Application Ref:

2021/0899

21 Hollin Moor View, Thurgoland

Proposed Ground Floor Plan

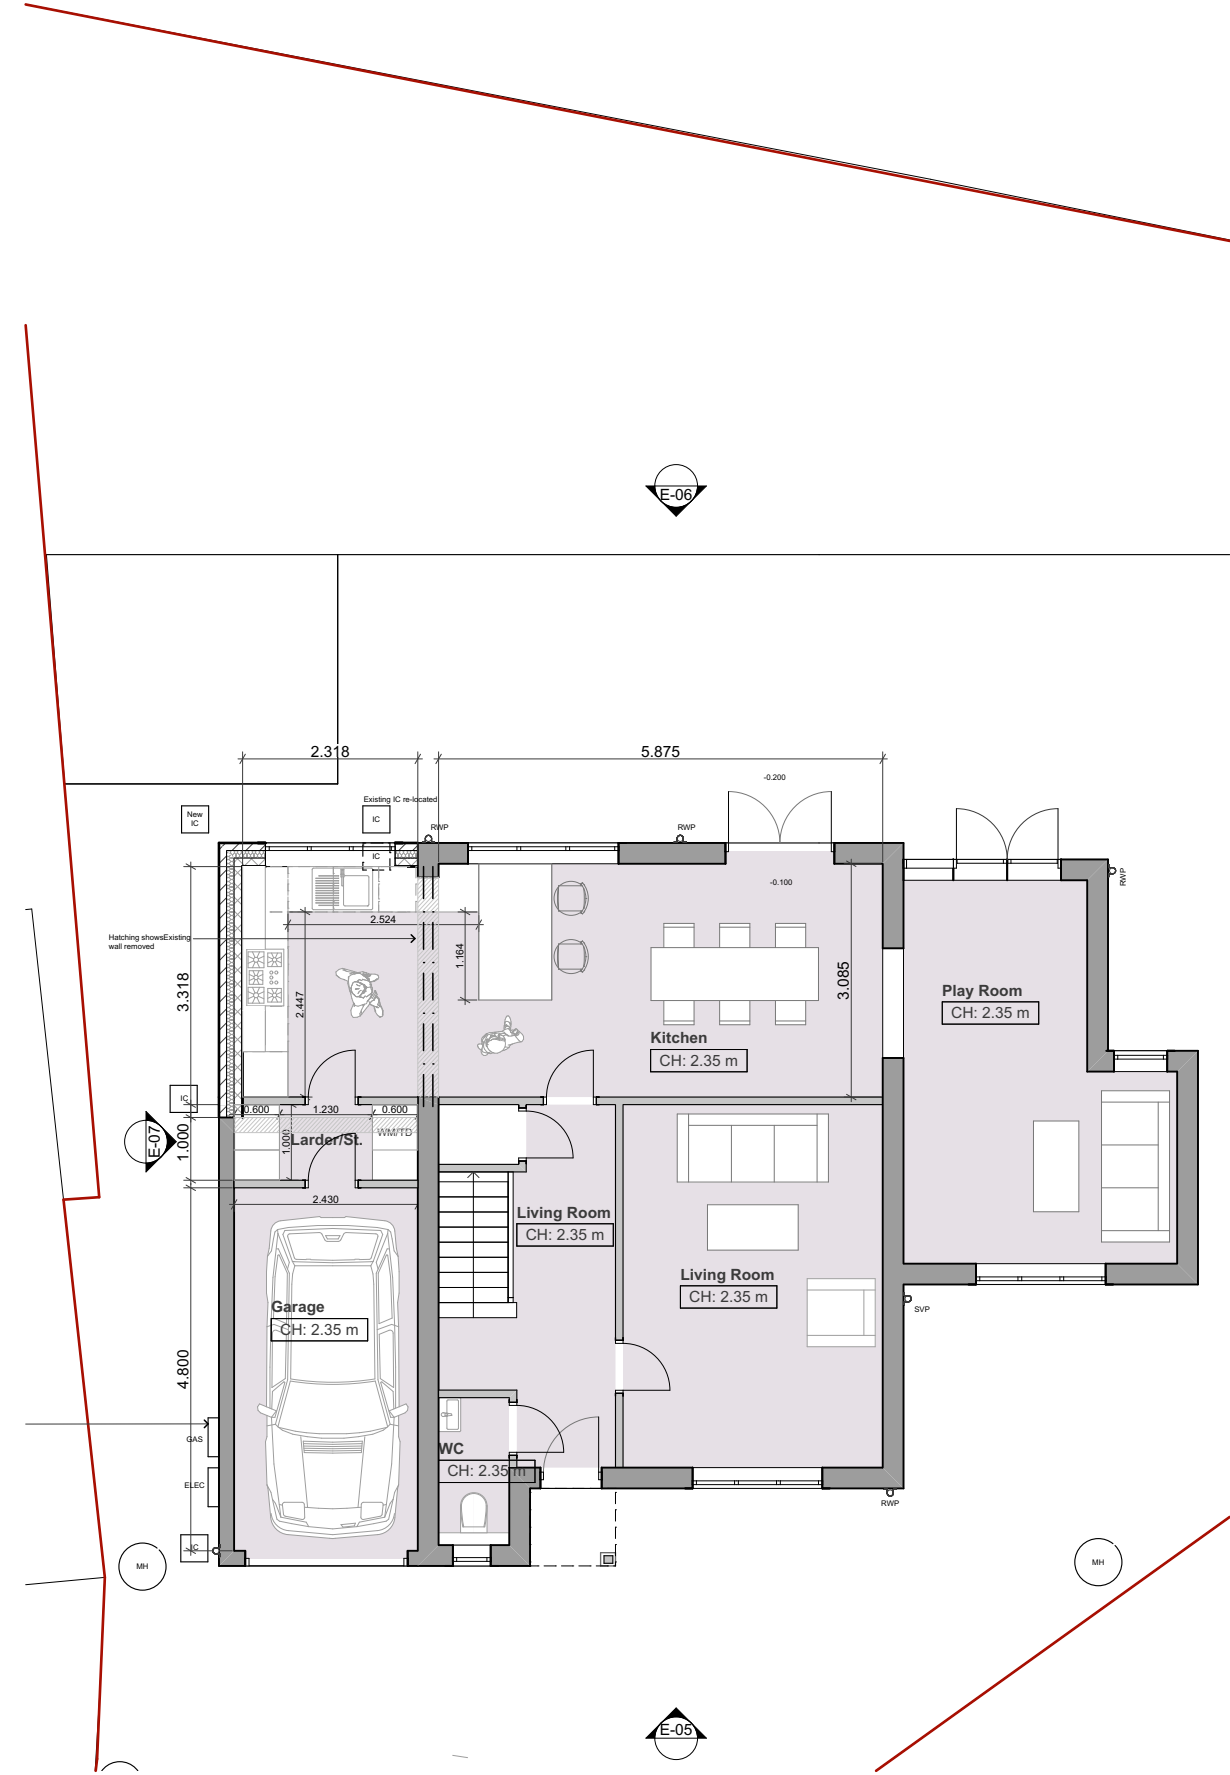
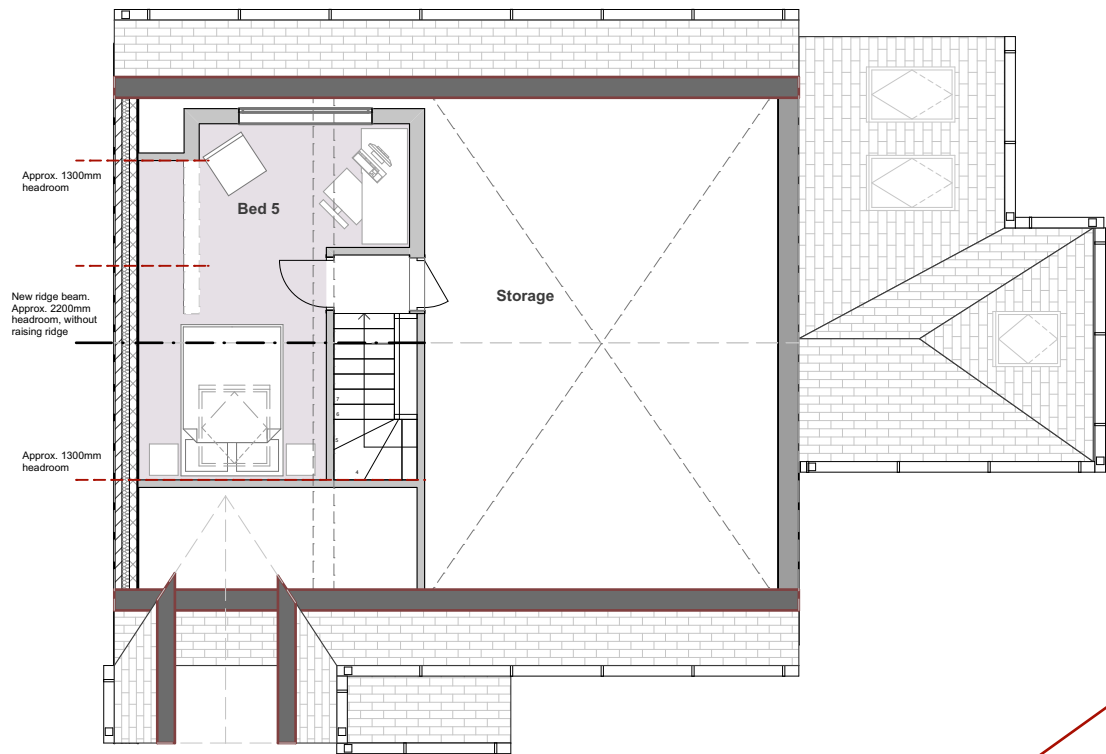
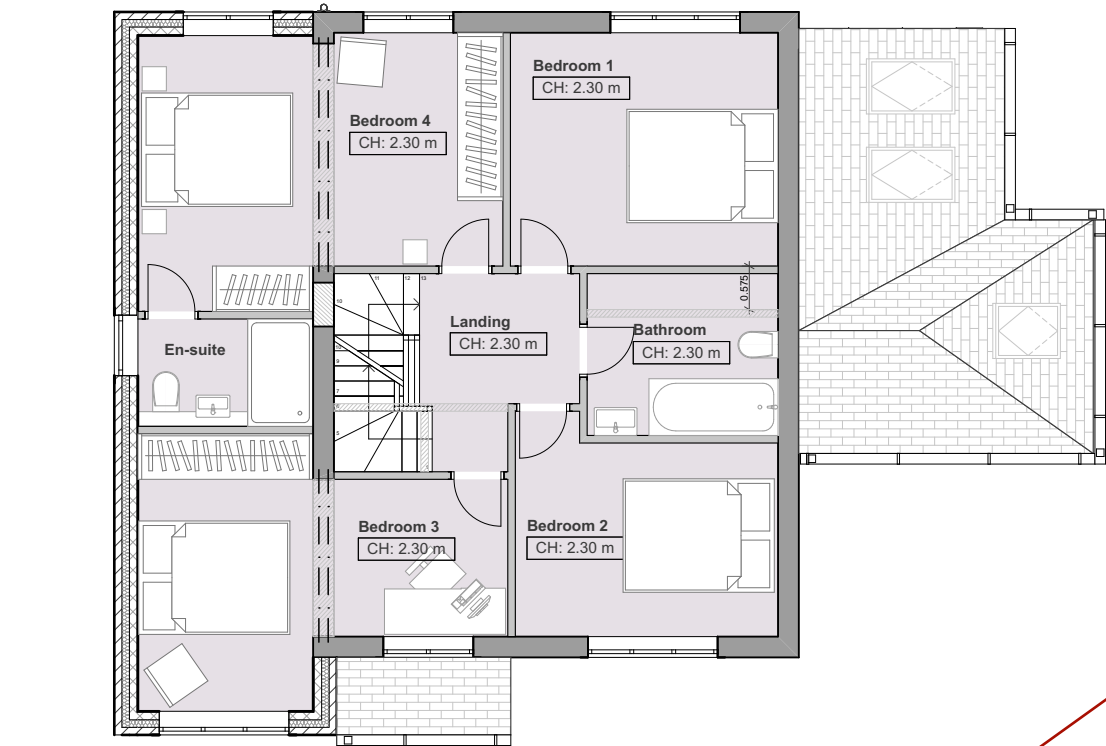
The proposal involves the erection of a two storey side extension including rear dormer extension to dwelling. The rear flat roof dormer would be permitted development. The extension has a front facing gable as it would extend over the existing integral garage. 1 rooflight is proposed to the front roof slope.

The extension would allow for extensions to the bedrooms at first floor and an additional room within the roof space as part of the loft conversion, which once constructed would be permitted development.

DORMER EXTENSION	
	Yes / No (include comment if required)
1. Pitched roof dormer on principle roof slope?	
2. Flat roof dormer on rear roof slope?	Yes - 1 Dormer to rear
3. Dormers in street scene & similar style?	No dormers within the street scene, but the dormer will be located on the rear elevation and not visible from the street scene so is acceptable.
4. Set below roof ridge?	Yes
5. Set in [ideally 0.5m] from both the eaves and gable edge?	Yes
6. Set in 0.5m from party walls?	Yes
